CITY OF ALBUQUERQUE

August 16, 2012

**Re: San Clemente Apartments Buildings C and D, Traffic Circulation Layout
Engineer's Stamp dated 07-03-12 (G14-D006A)**

EXHIBIT "A"
TRAFFIC CIRCULATION LAYOUT

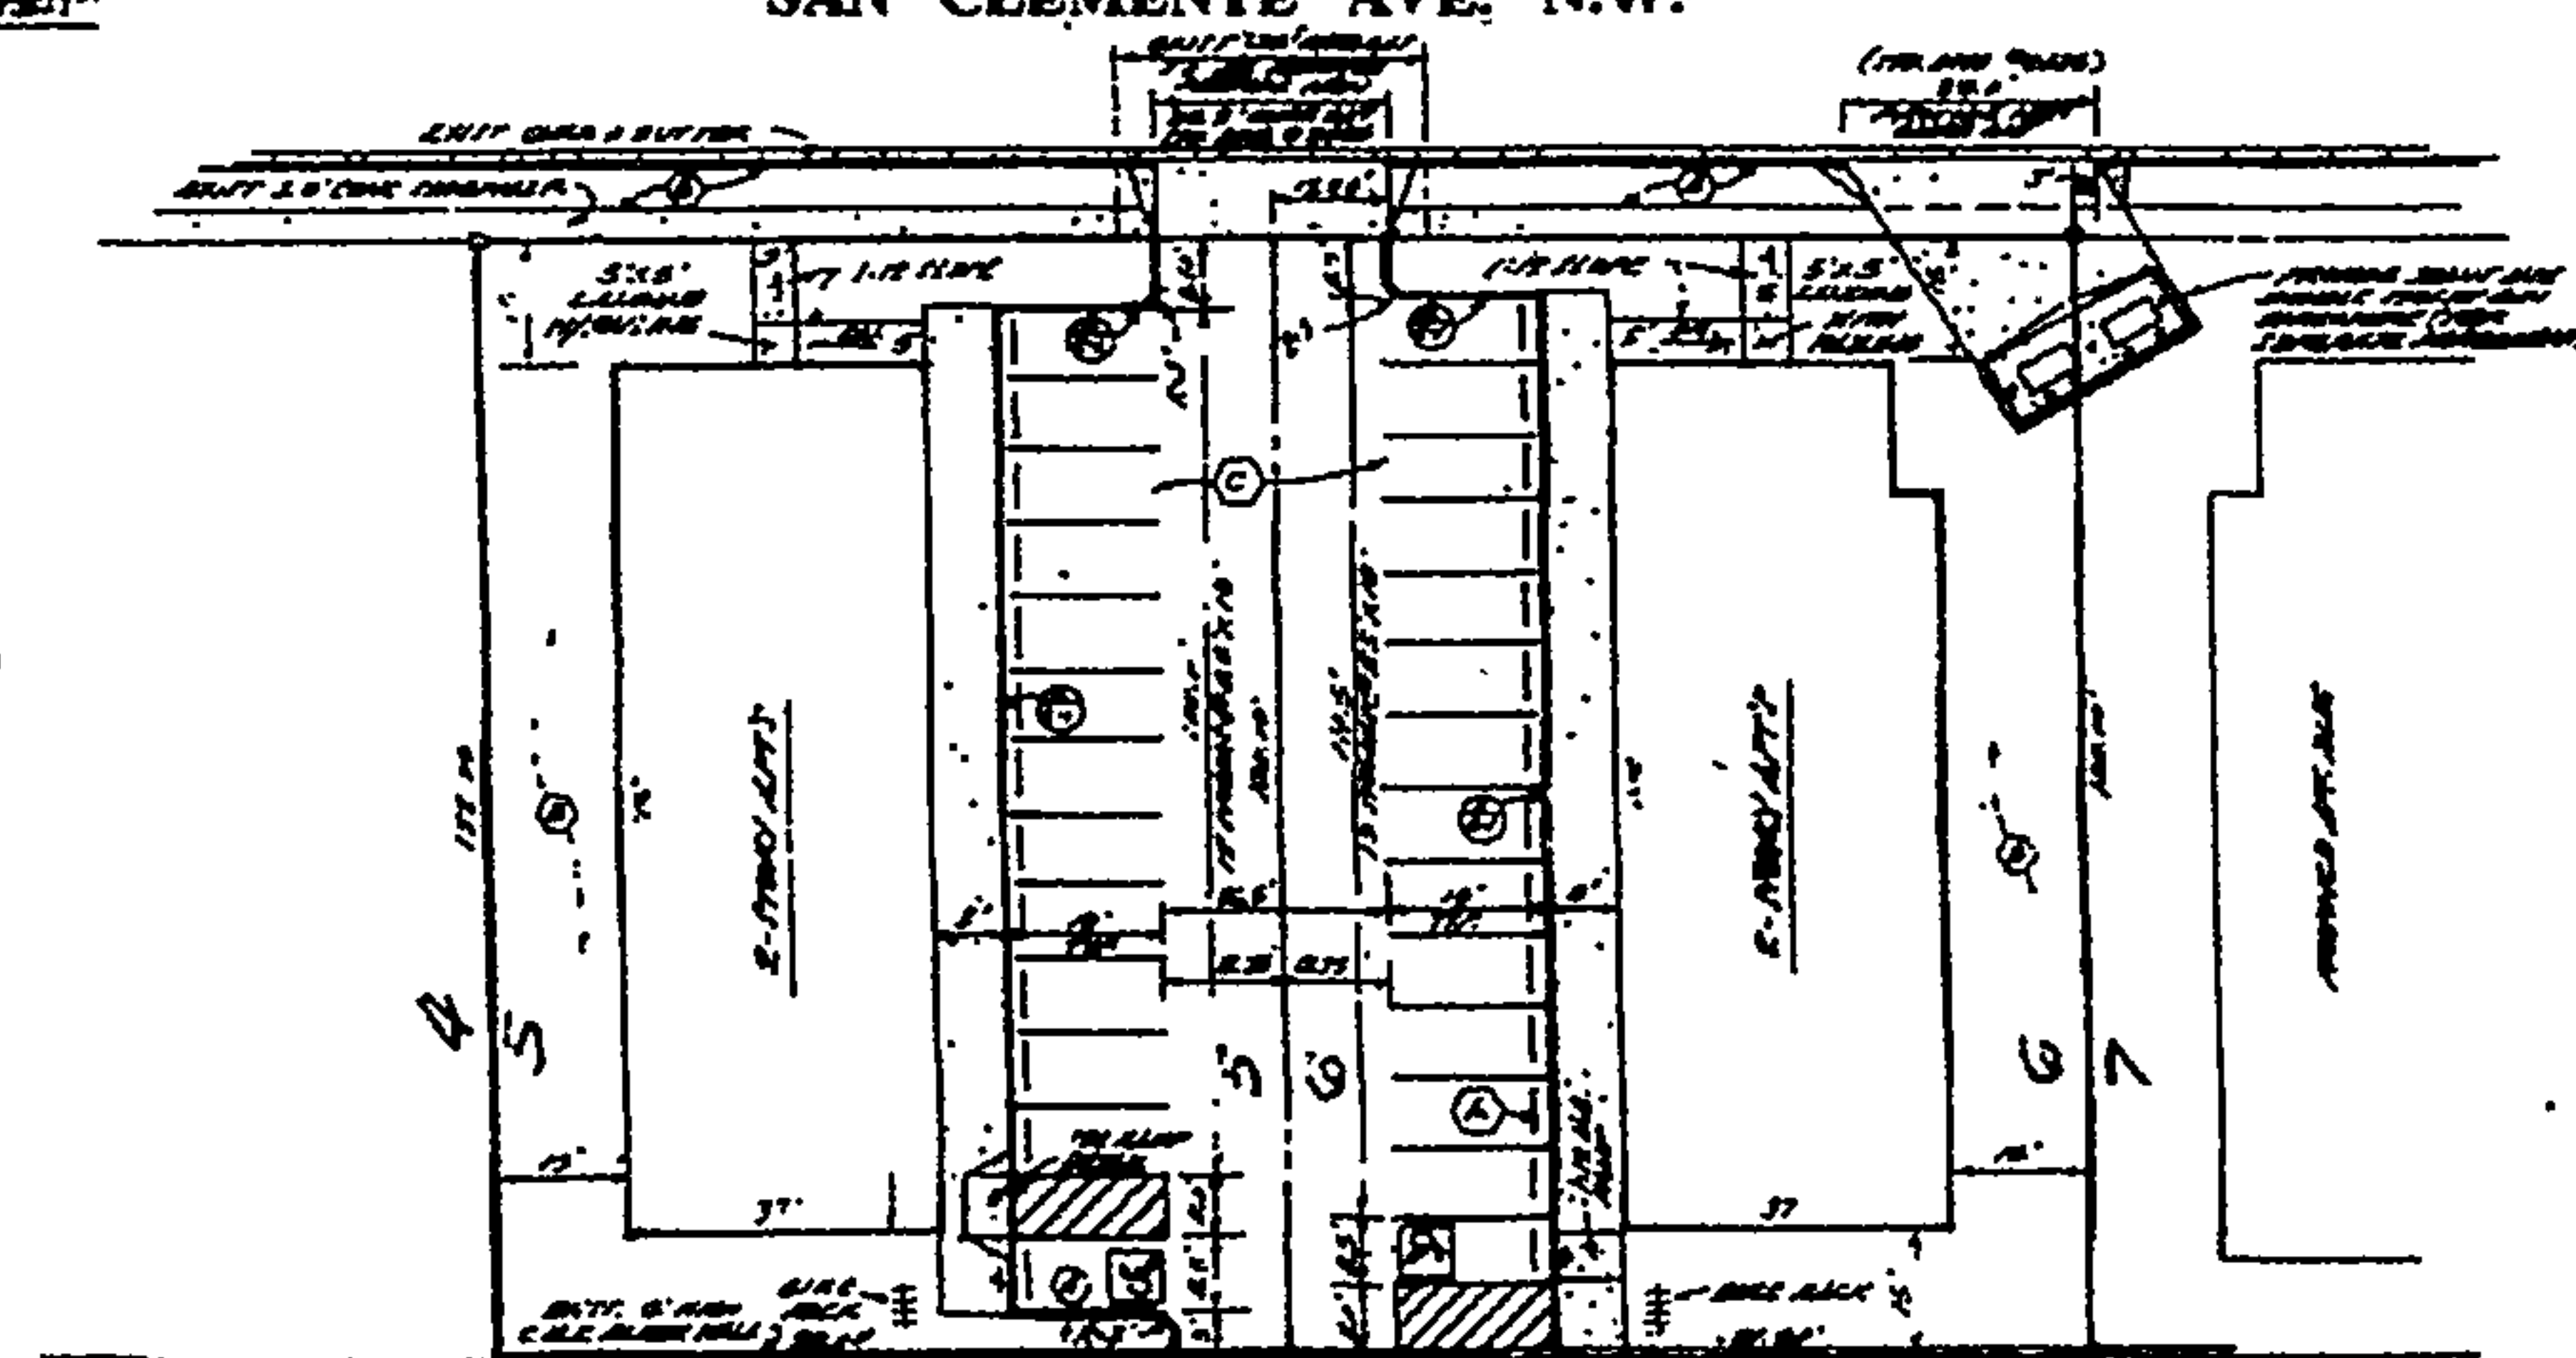
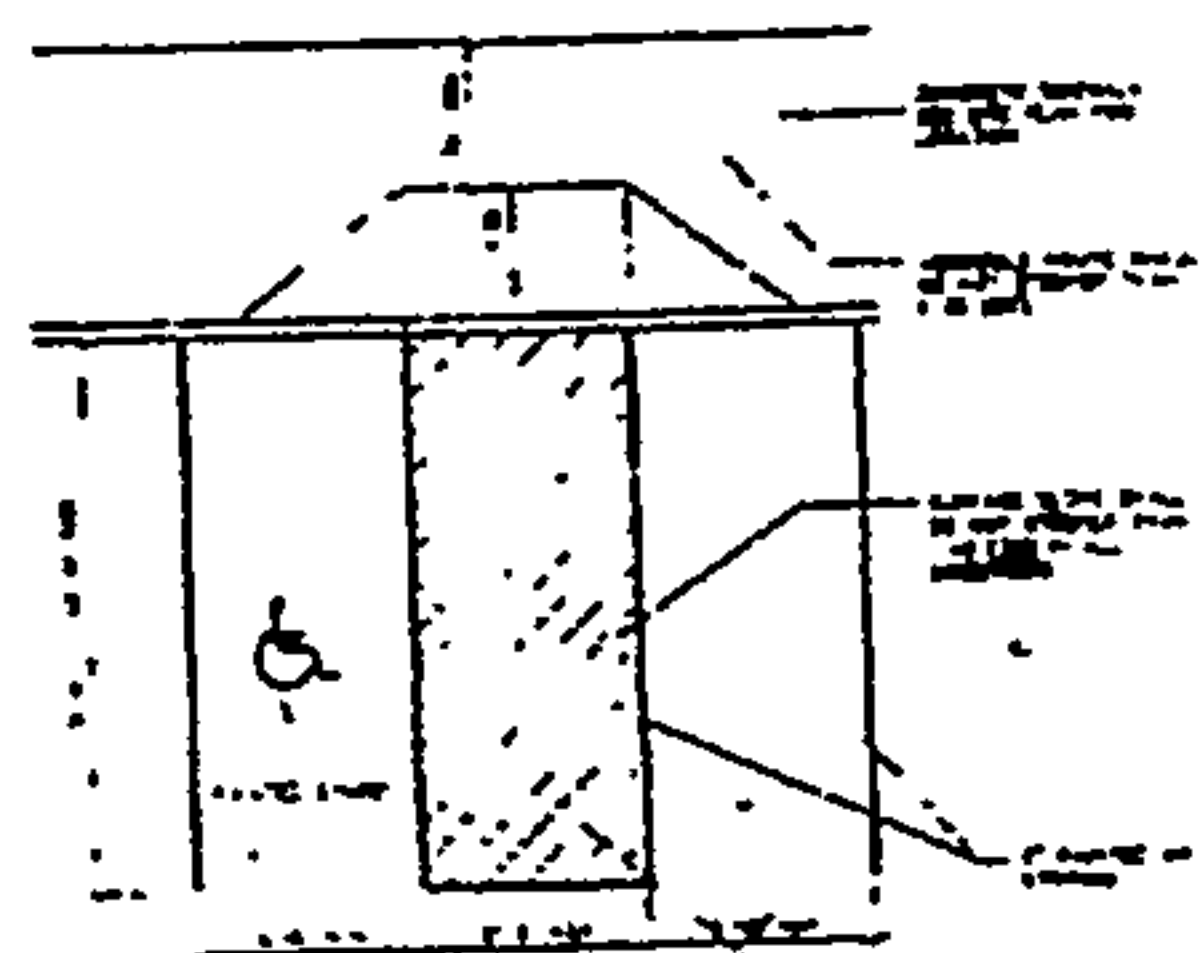
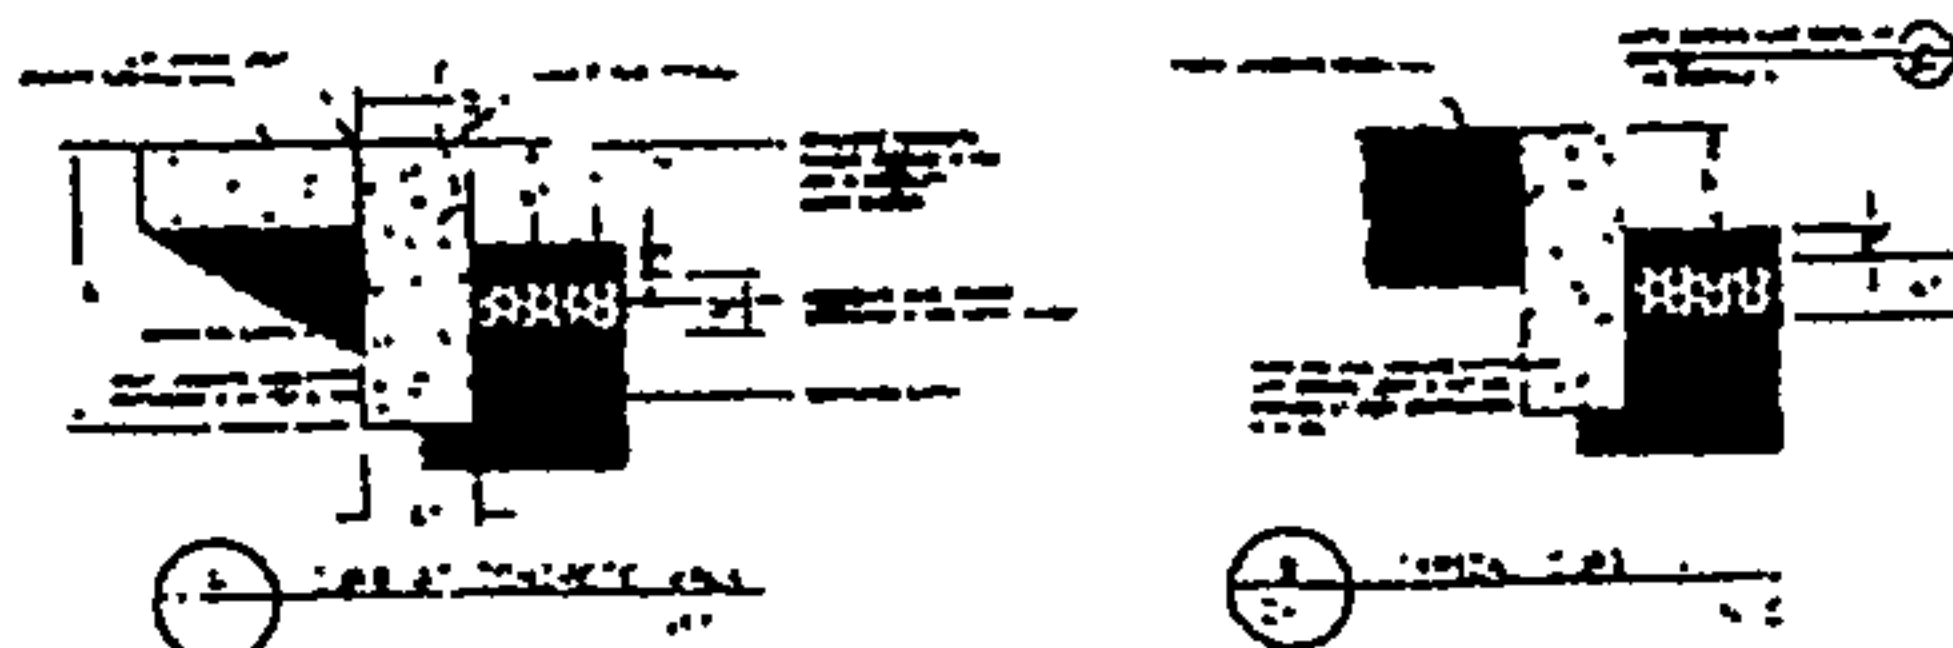
1. All proposed sidewalk must be a minimum of 4-foot in width.
2. Provide a copy of the shared access agreement between lots 5 and 6, lots 4 and 5, and lots 6 and 7.
3. Recent aerial information shows no sidewalk along this frontage; please clarify.
4. The proposed 4-foot high screen wall (keyed note D) appears to interfere with the sight distance for the entrance. Please provide a sight distance exhibit.
5. Provide the address for the site.
6. The proposed 4-foot high screen wall (keyed note D) blocks the ADA pathway from the roadway to the buildings. Please revise.
